Please review a plat that as stated in review 1 for the standards. ADD the standard surveyor language above the legal.

URBAN COLLECTION AT PALMER VILLAGE

SHEET 1 OF 8

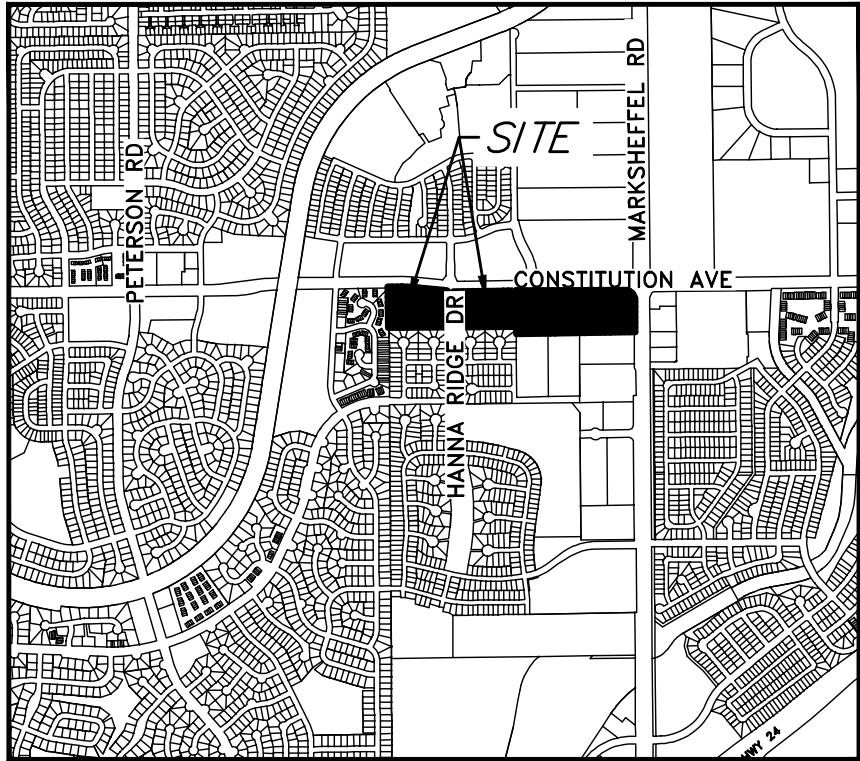
This will be signed by the hOA ; please add the acceptance certificate like the example provided

you need a notary for each owner/ plat signer

This is odd; i dont recall this as a standard note in the County, (and the Code is 2019). DELETE THIS
